July 31, 2019

RE: TREE CONSERVATION REPORT – 21 WITHROW AVENUE, OTTAWA (ADDENDUM)

TCR
 TREE
 CONSERVATION
 REPORT

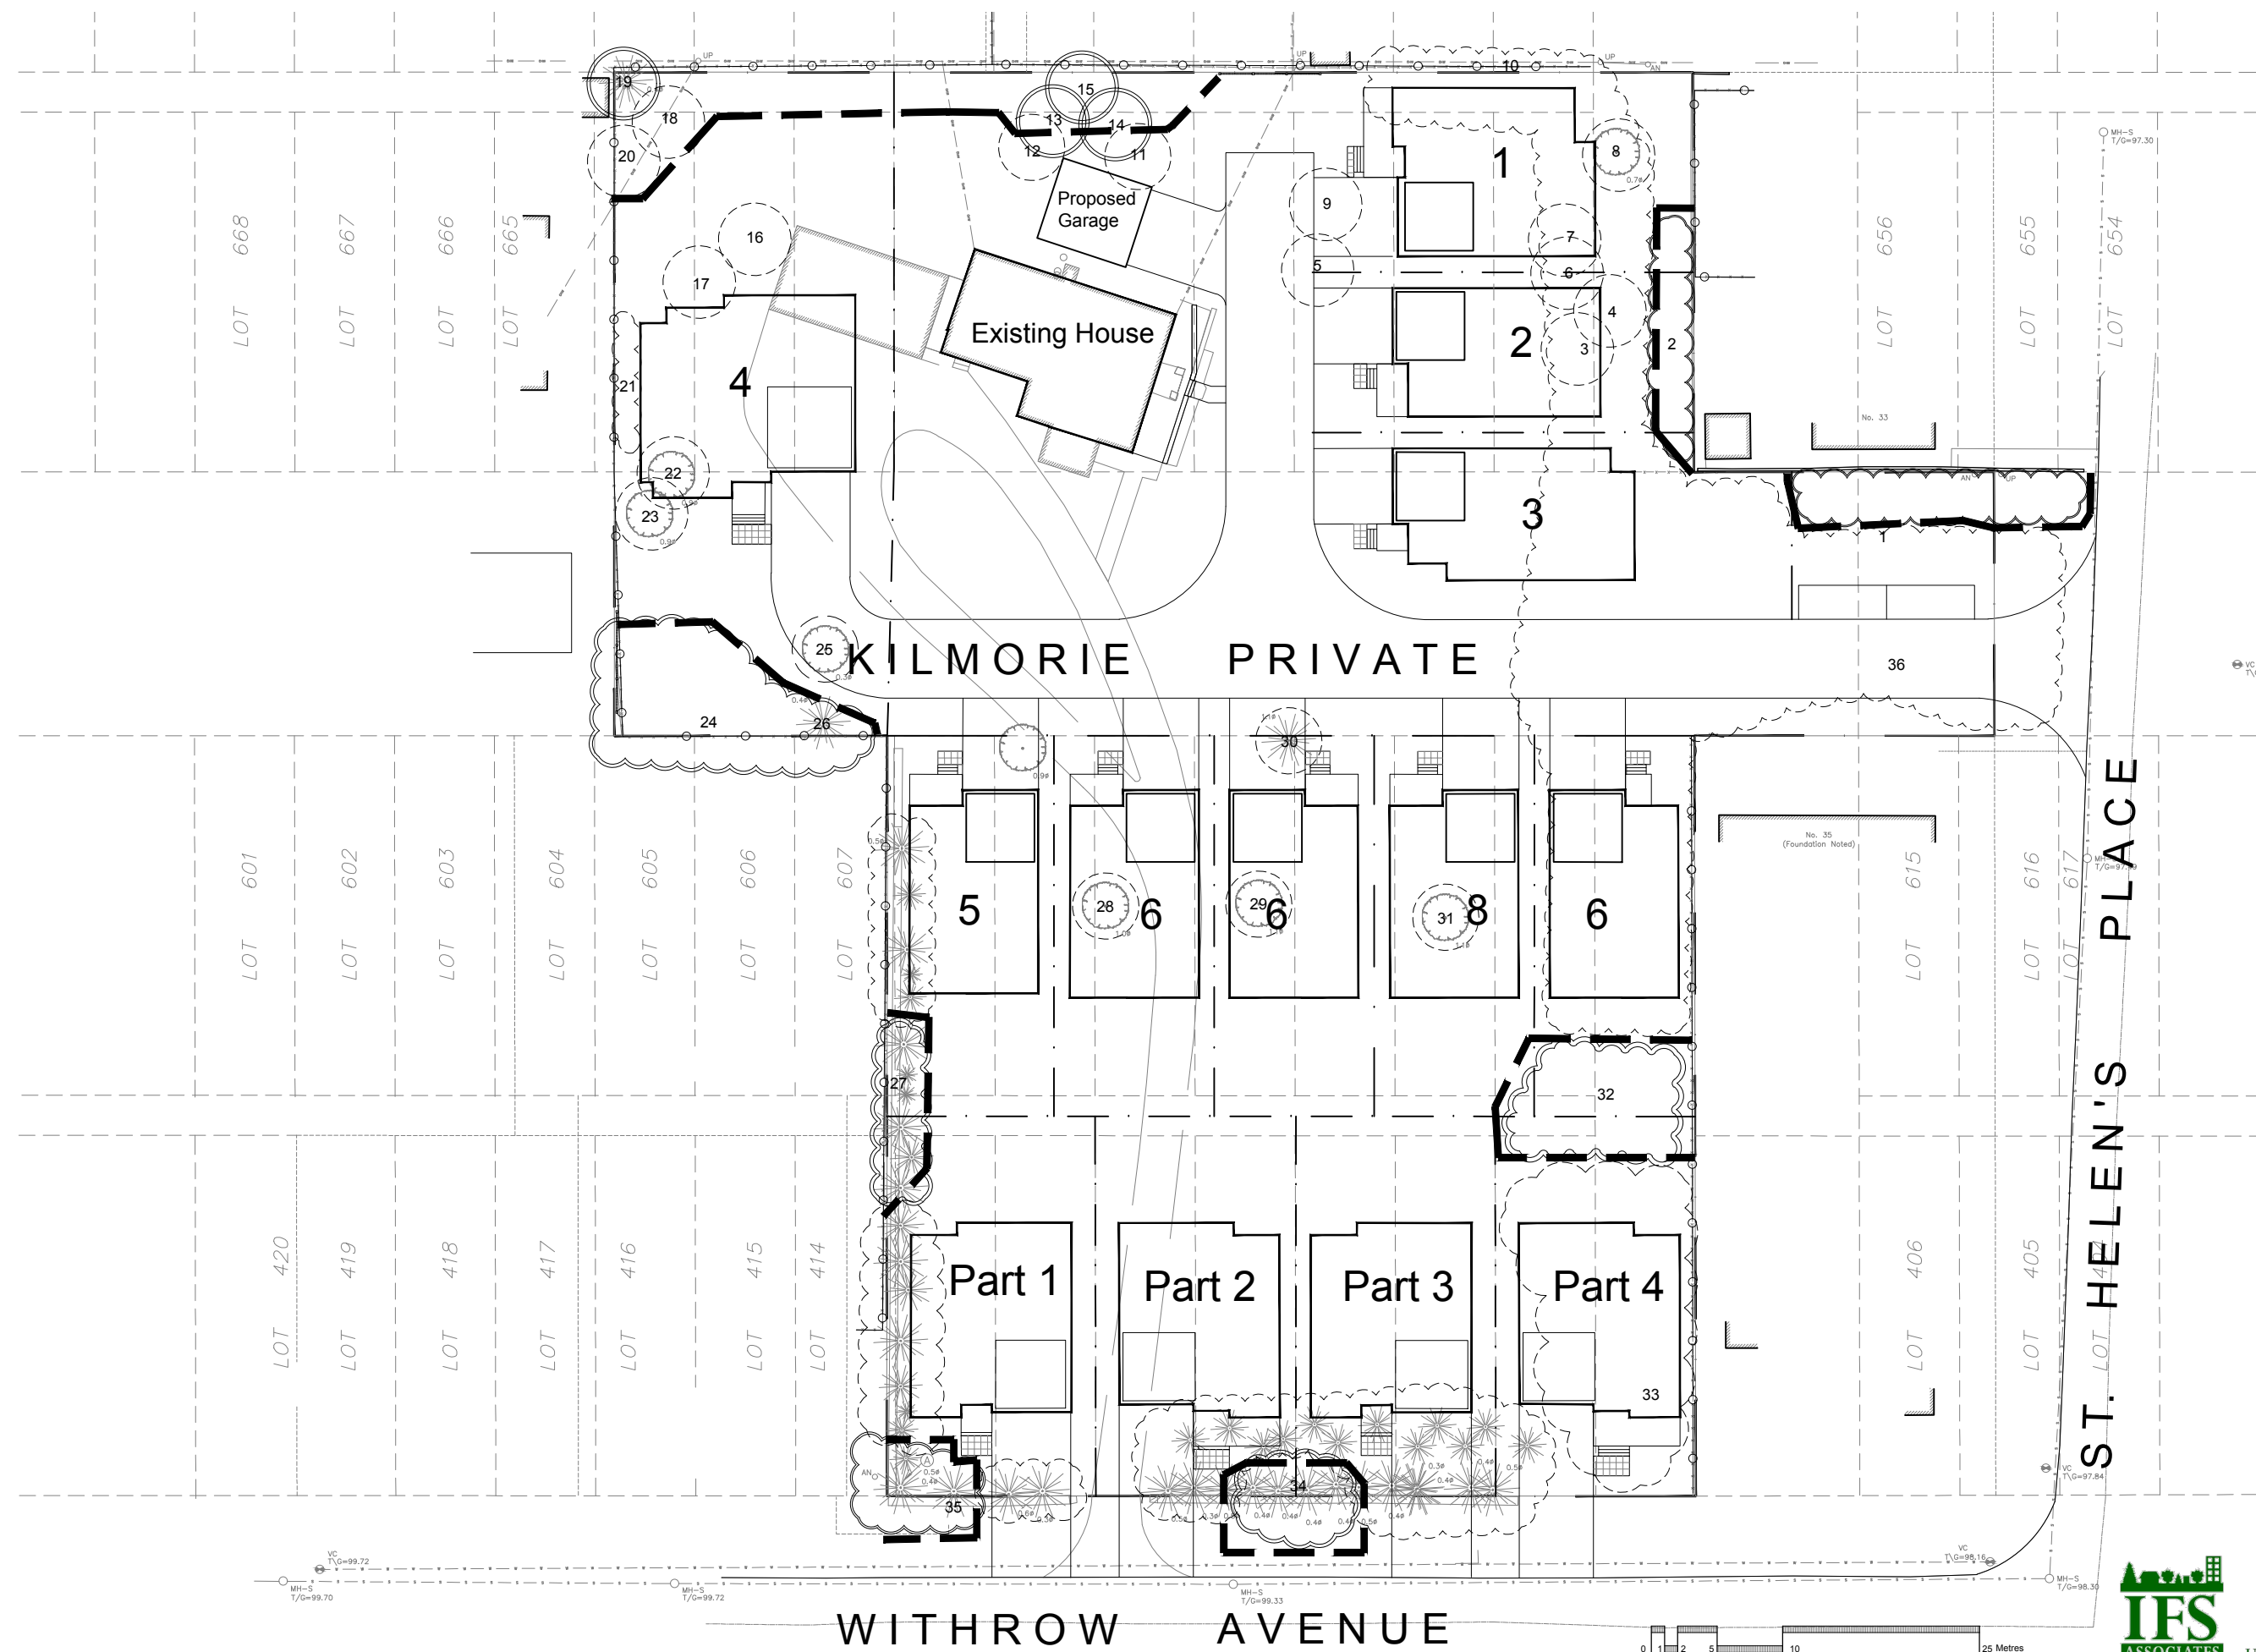
This brief report serves as an addendum to the Tree Conservation Report (TCR) prepared by *IFS Associates Inc.* for the above-noted property on May 13, 2019. The need for this addendum is related specifically to tree #34 – a grouping of Norway spruce located adjacent to Withrow Avenue (see relevant section of Table 1 below taken from the original TCR). Although originally slated for preservation and protection, the requirement by Hydro Ottawa to bury their lines along Withrow Avenue and the installation of a pedestal transformer within this grouping of trees requires they be removed instead. They will not survive the excavation necessary for this work.

Tree No.	Tree Species	Condition (VP→E)	DBH ¹ (cm)	Tree Condition Notes & Preservation Status (to be removed or preserved and protected)
34	Portion of spruce line: 13 Norway spruce and 21 white spruce	Fair-Good	Norway 28-47; white 6-21	Mature; line of white spruce generally suppressed by faster growing Norway spruce located to south; planted; to be removed due to conflicts with underground Hydro lines and pedestal transformer
